**RE: DRB CORRECTION TO THE DRB APPROVED SITE PLAN AMENDMENT PROJECT #1000389 / SI-2021-01915 – NEW PROJECT #PR-2021-006237**

Modulus Architects, Inc., hereafter referred to as “Agent” represents Sun Center Partners LLC., hereafter referred to as “Applicant”. The Development Review Board (DRB) held a public meeting for Site Plan Amendment (SI-2021-01915) SITE PLAN AMENDMENT and a Waiver (VA-2021-00451 WAIVER) and approved the following actions at that meeting. Subsequently, an error was found on our Site Plan so we are requesting a CORRECTION to the following actions:

SITE PLAN-MASTHEAD PARKING LOT
1" = 20'-0"

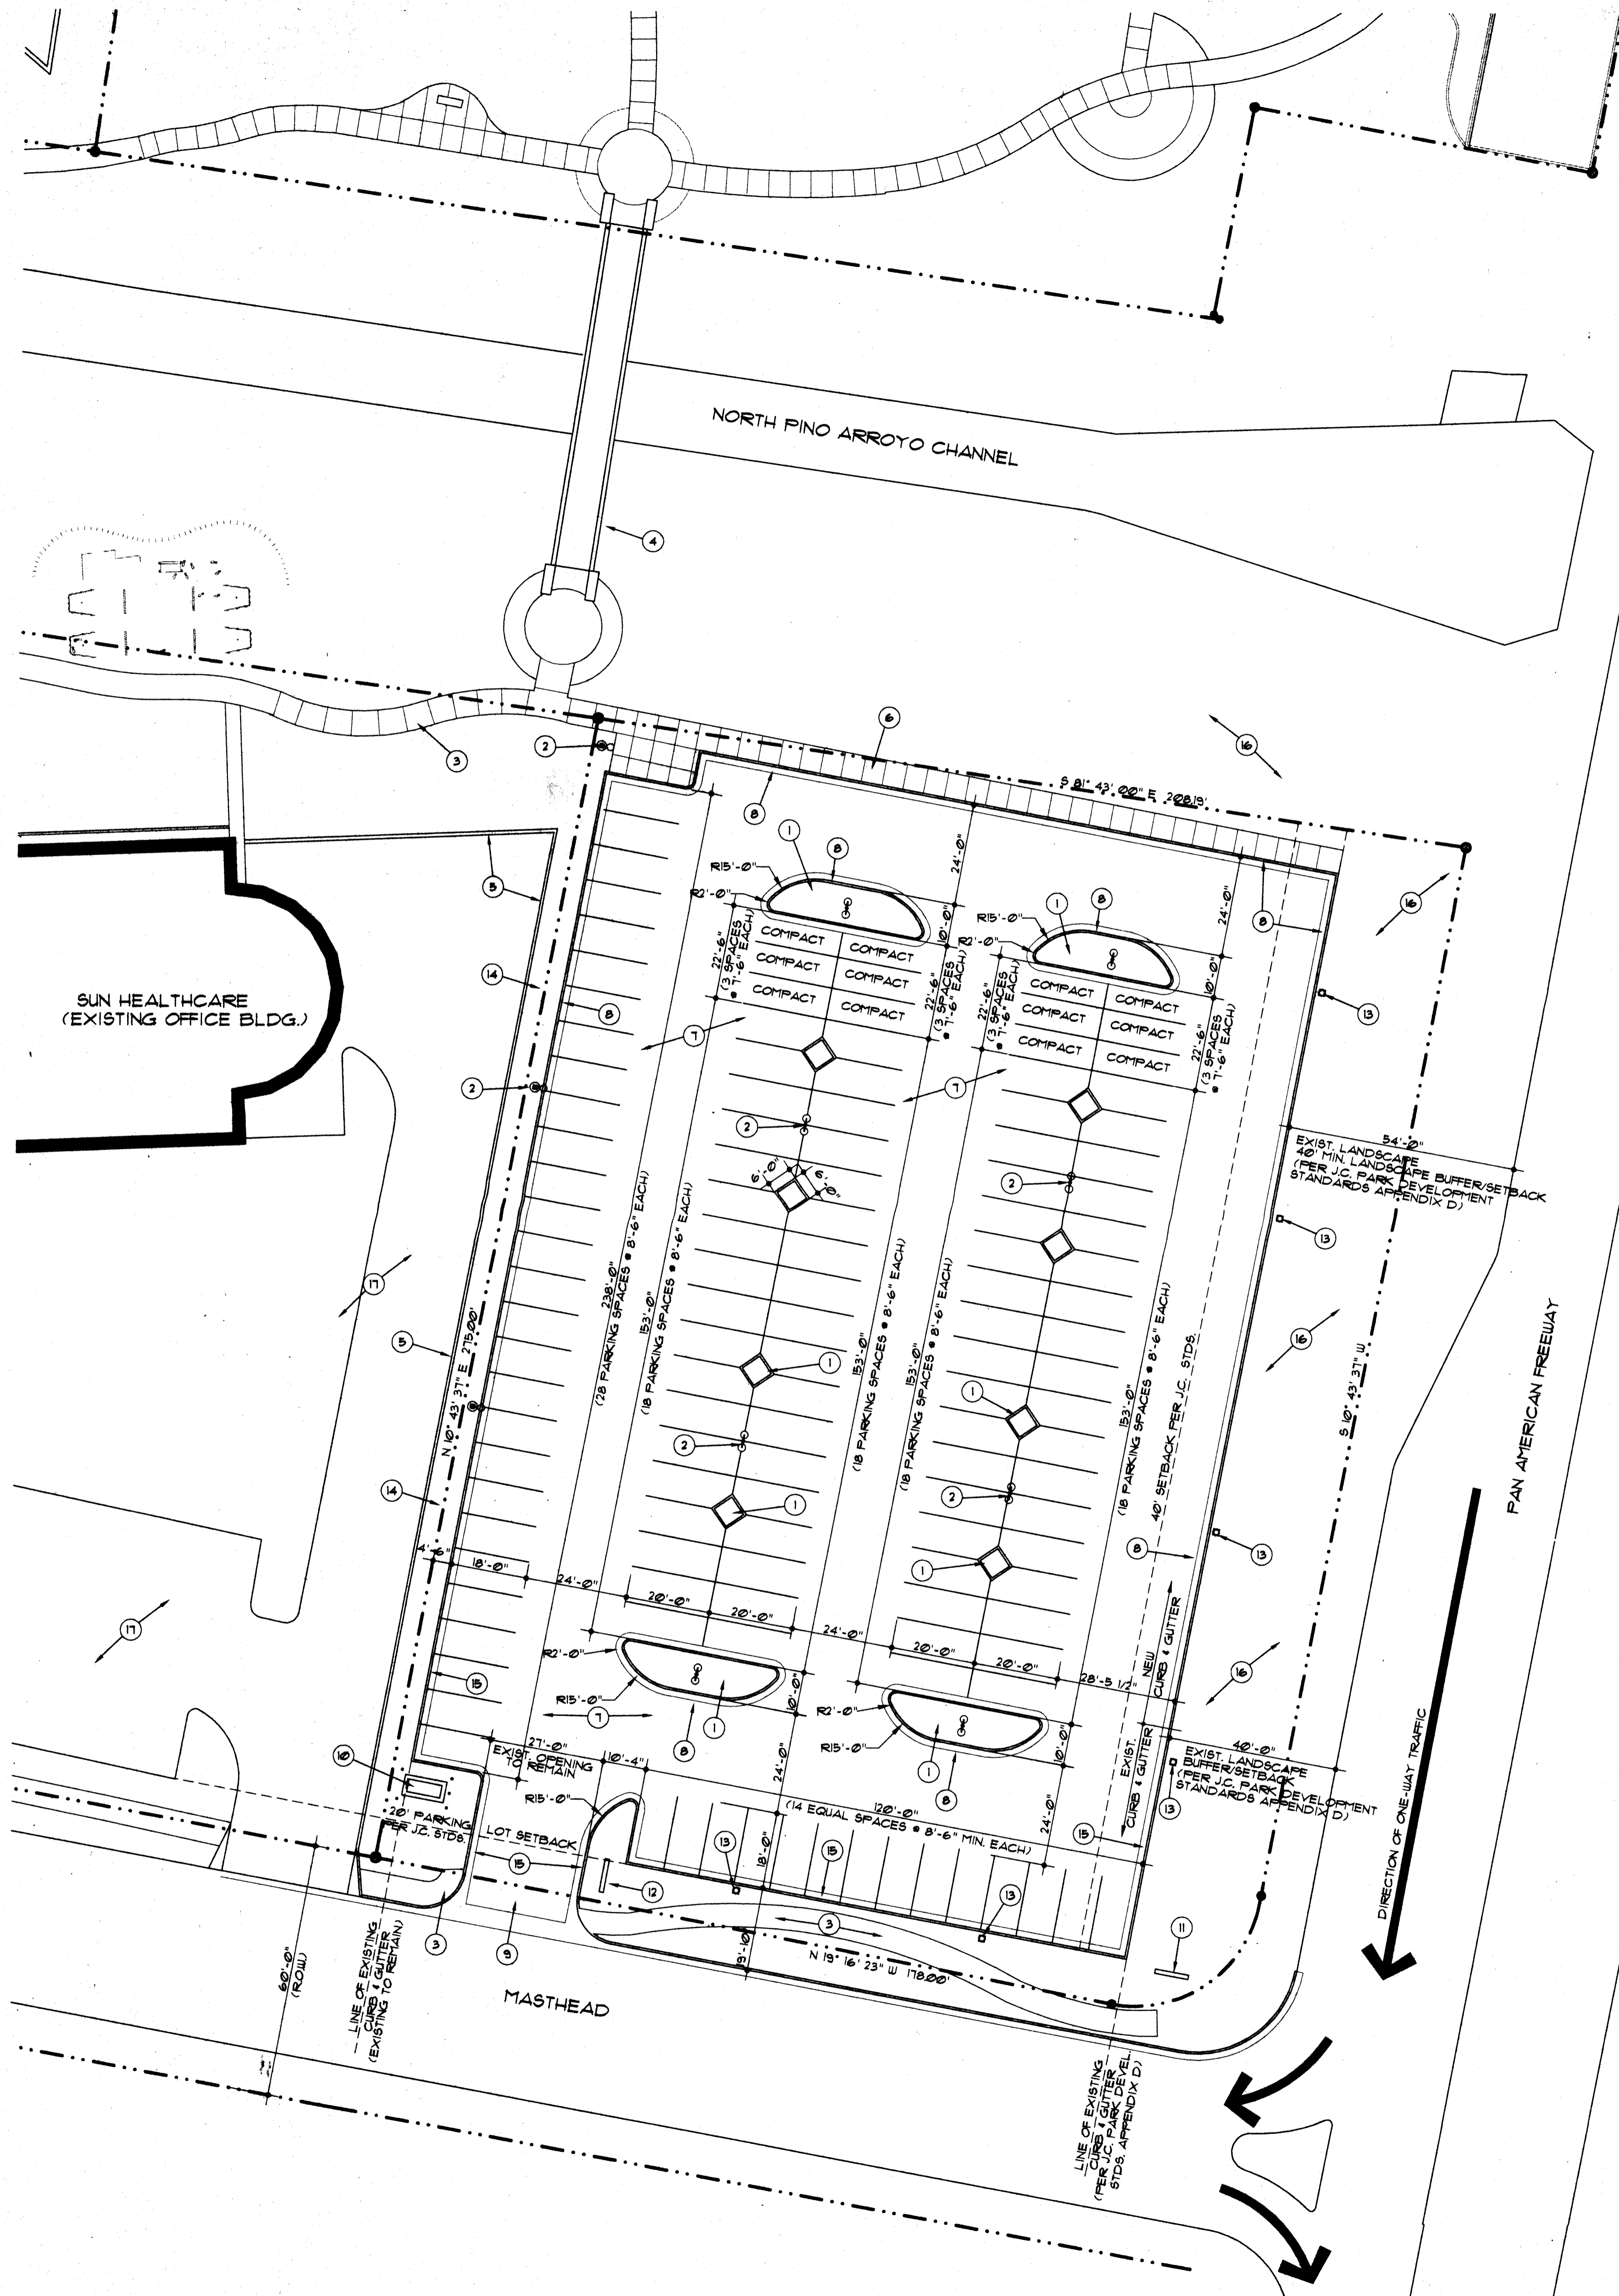
The overall Campus Site Plan included 5141 Masthead ST NE (TR 4AA-3B) however this structure was left off the site plan and the parking requirement for this structure was incorrectly left off the plan and was shown as a parking lot only when in actuality, there is a building consisting of 10,395 square feet on this site. This CORRECTION to the previous DRB Amendment correctly identifies this structure on the Site Plan. The approved DRB plans showed Tract 4AA-3B with a parking lot that had 126 spaces which in fact only had 67 spaces with an old building that remained.

In addition to this correction, we have provided updated parking calculations per the Parking Study Reduction approved by the Planning Director on April 25, 2022 per IDO 5-5(C)(5)(e). We are requesting a CORRECTION that shows the current condition of the site on the site plan and to update the current parking calculations.

We would like a Correction to reflect the current conditions and to have an accurate parking count for the overall Site Plan. Our submittal includes the approval letter from the City of Albuquerque regarding the Parking Study Reduction.
